From: Jeff Tarling
To: Jean Fraser
Date: 3/13/2014 8:48 AM
Subject: Re: Need comments now for PB Workshop Memo- 421 Warren (2014-016)

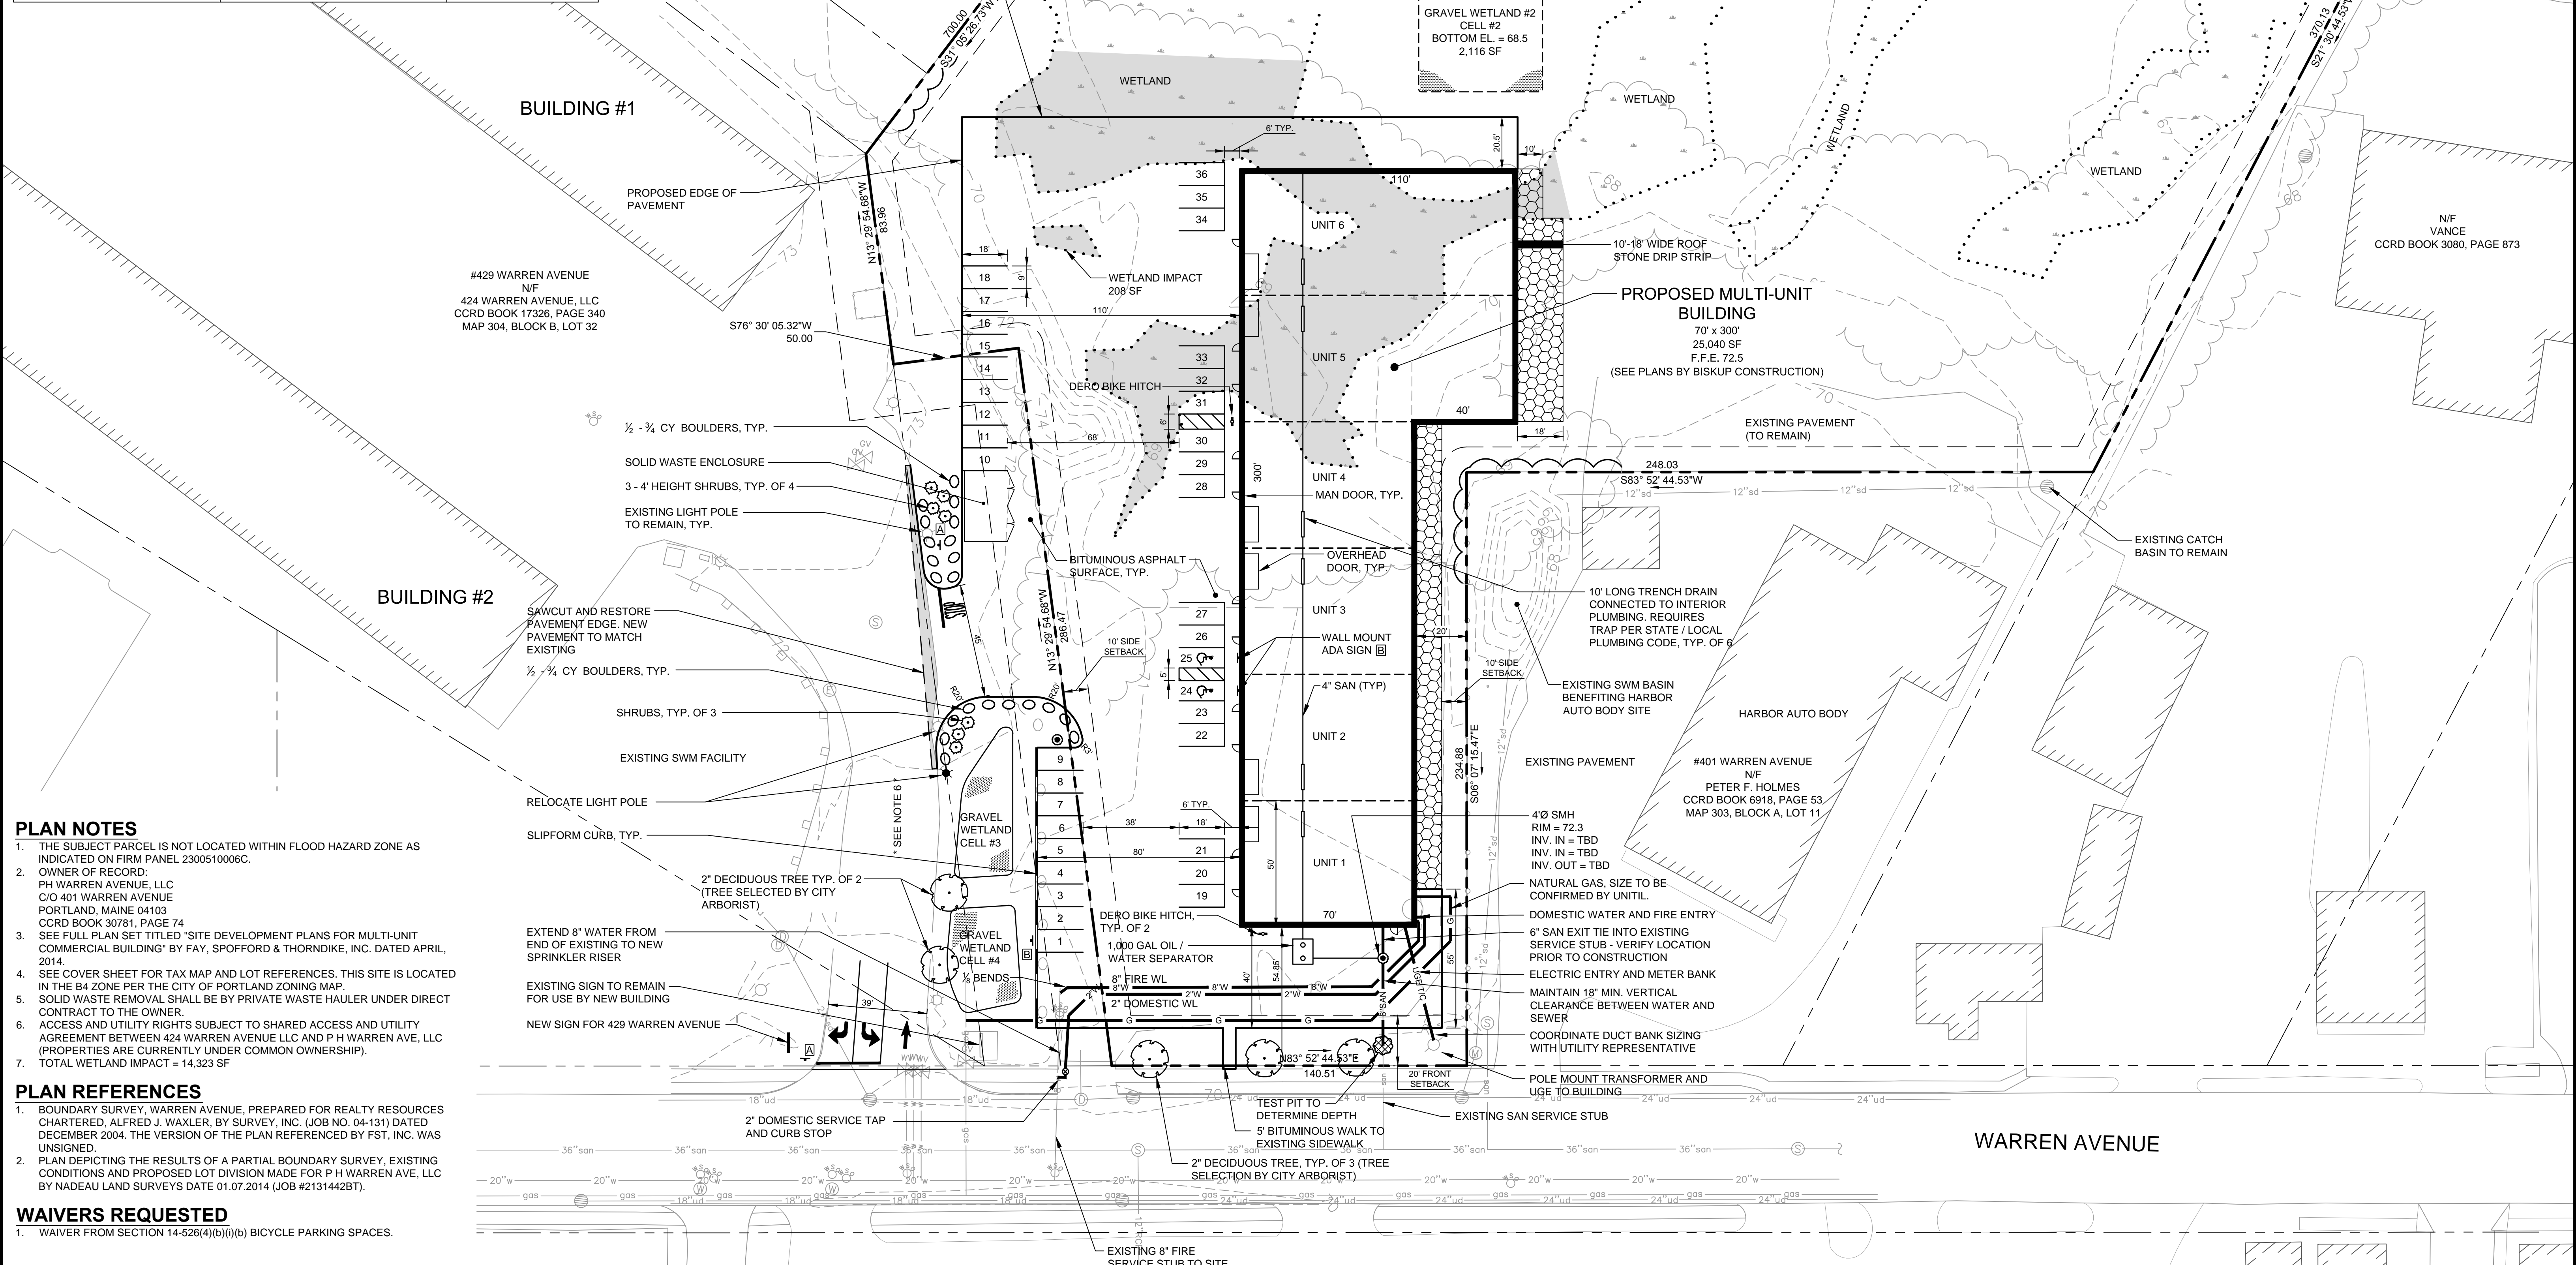
The proposed 421 Warren Avenue project is in need of a 'tree save' plan. Hopefully, trees along the edge of the proposed development could be saved and if not the project should show replacement planting plans per city standards.
